DEVELOPMENT REVIEW BOARD
SUPPLEMENTAL SUBMITTAL

PROJECT NO. PR-2019-002277
Application No. SI-2019-00246

SUBMITTAL DESCRIPTION: DRB Site Plan Resubmittal.

**RE: Adagio Apartments
PR-2019-002277**

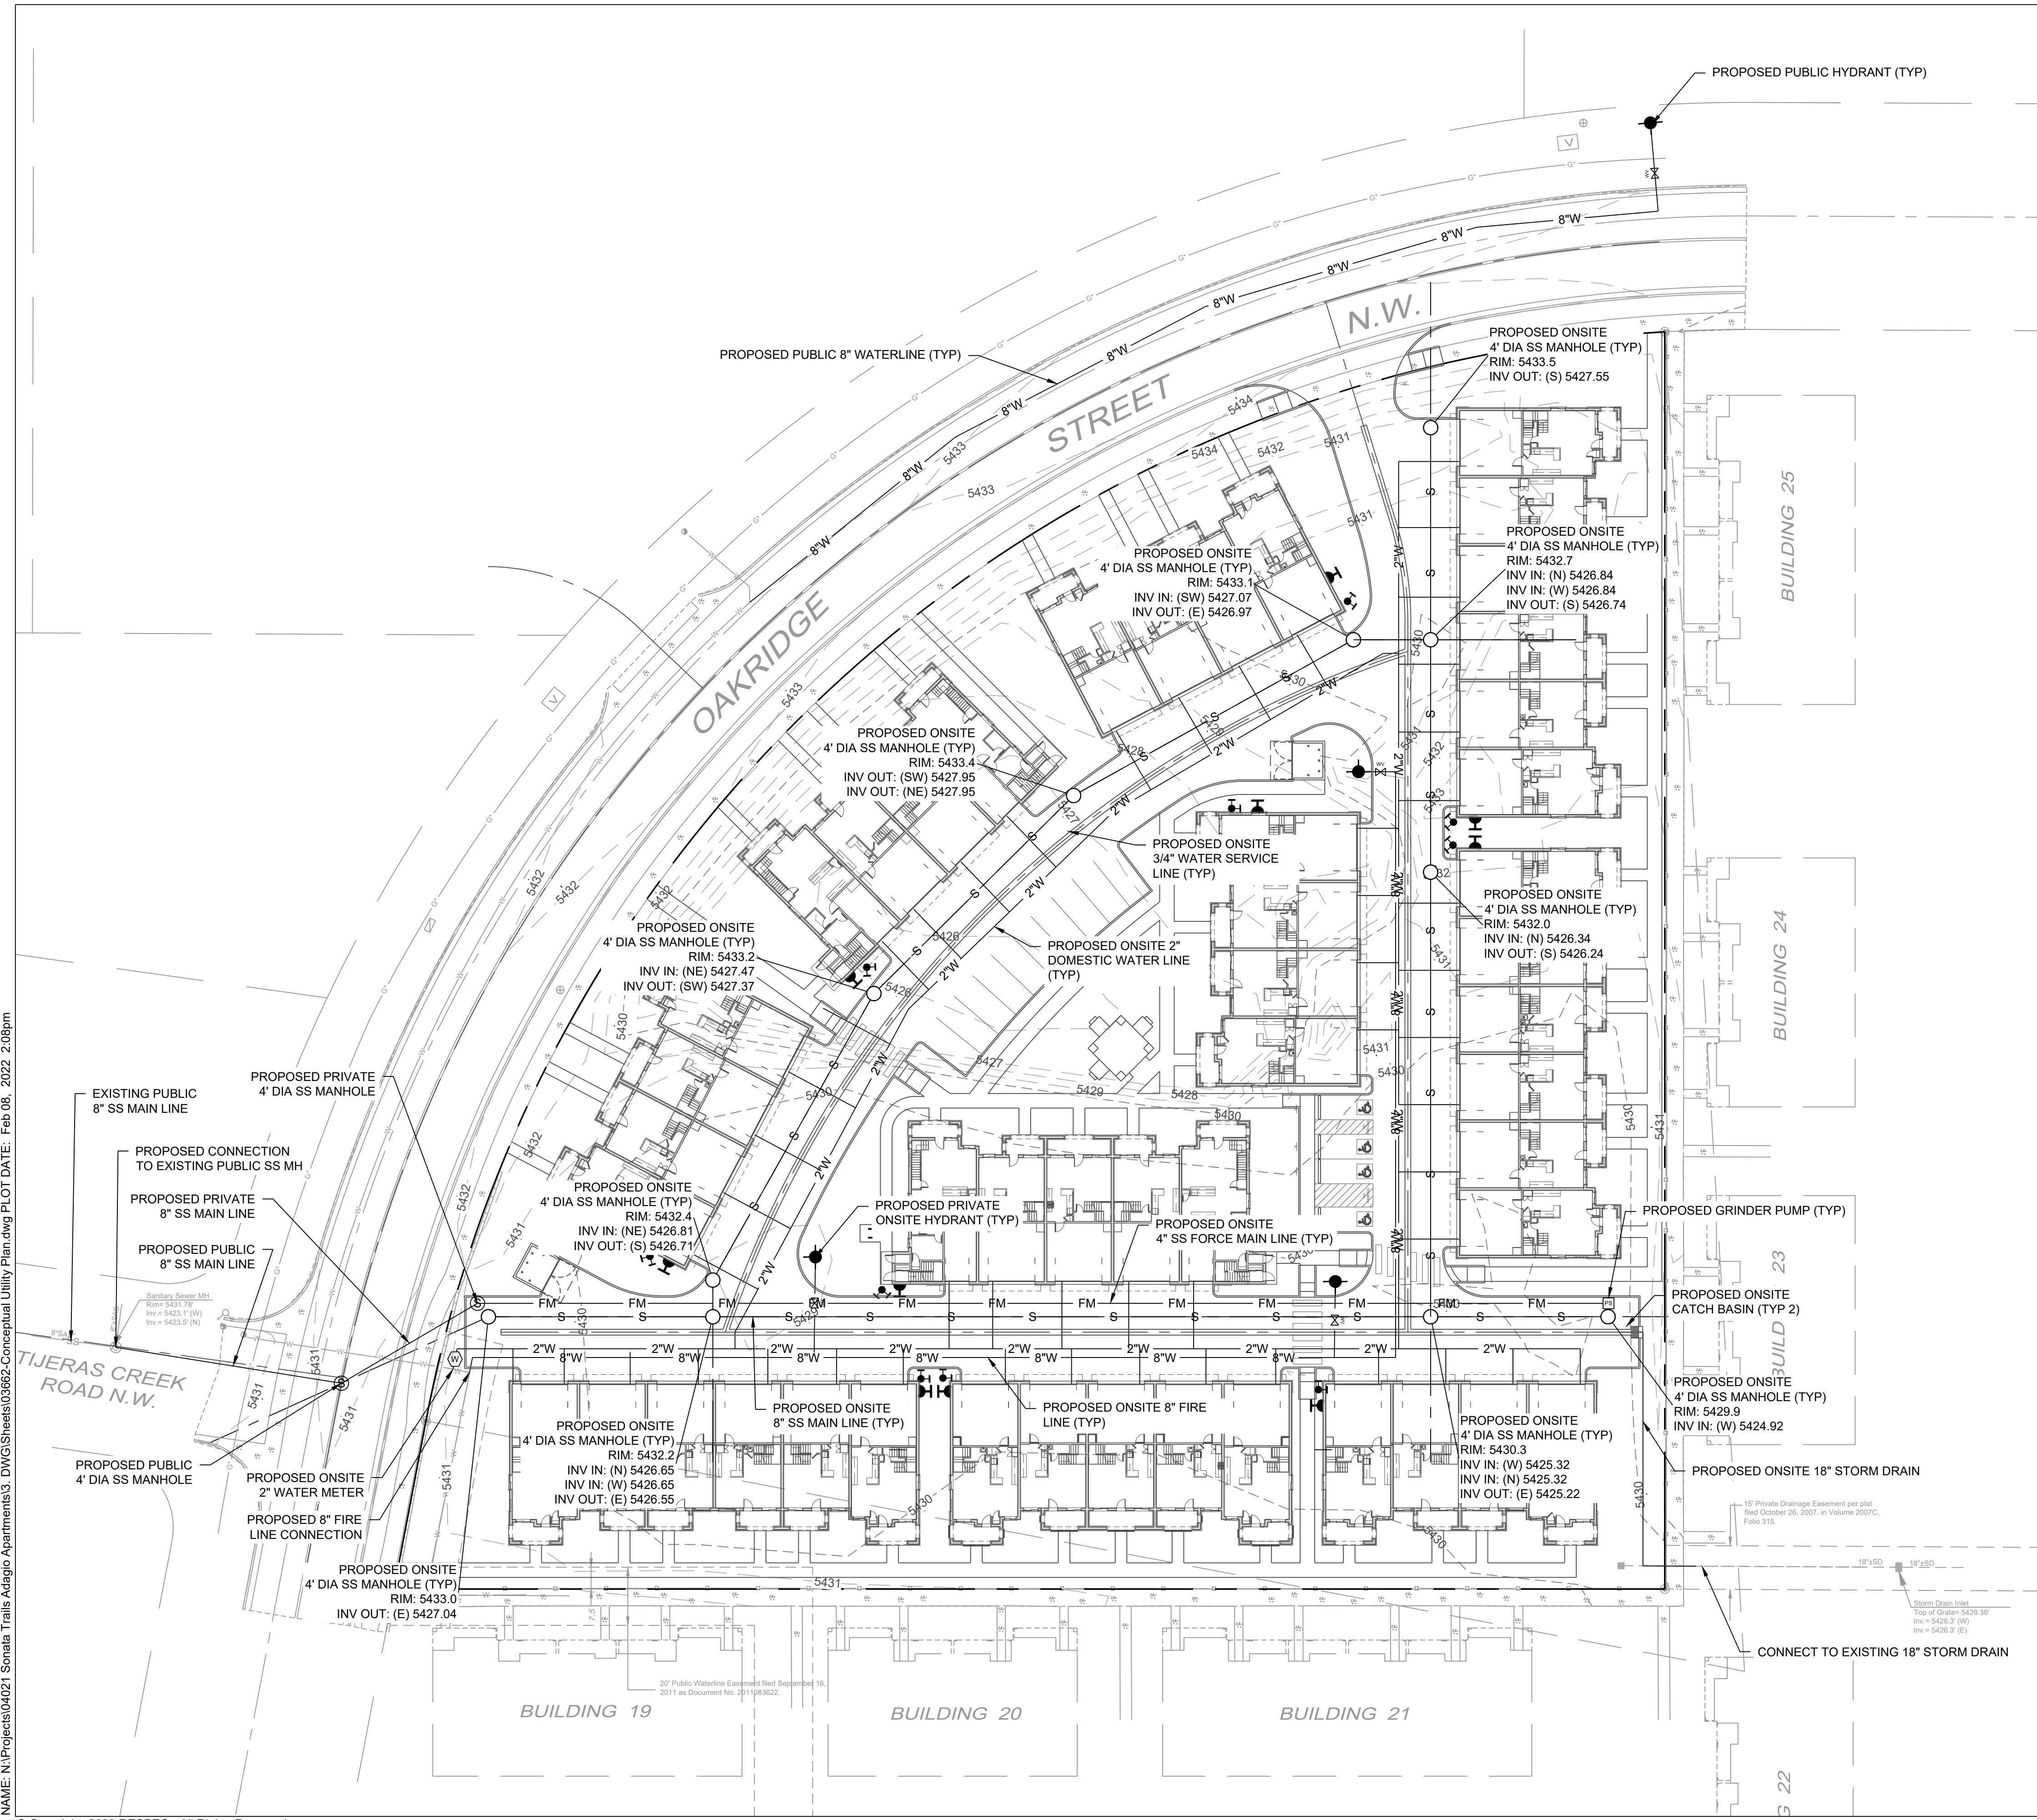
- / Utility Plan
 - The connection to the manhole in Oakridge will need to be a private connection. The force main onsite will not be publicly maintained. Preferably the force main would tie into a manhole onsite which would gravity flow into the public main.
 - *Response: Agreed. See revised utility plan attached.*
 - Call out the connection location and sizes for each connection.
 - *Response: Connection locations and sizes have been called out. See revised utility plan attached.*
 - Public waterline and sanitary sewer is not desired onsite.
 - *Response: No public waterline nor sanitary sewer is being proposed onsite.*
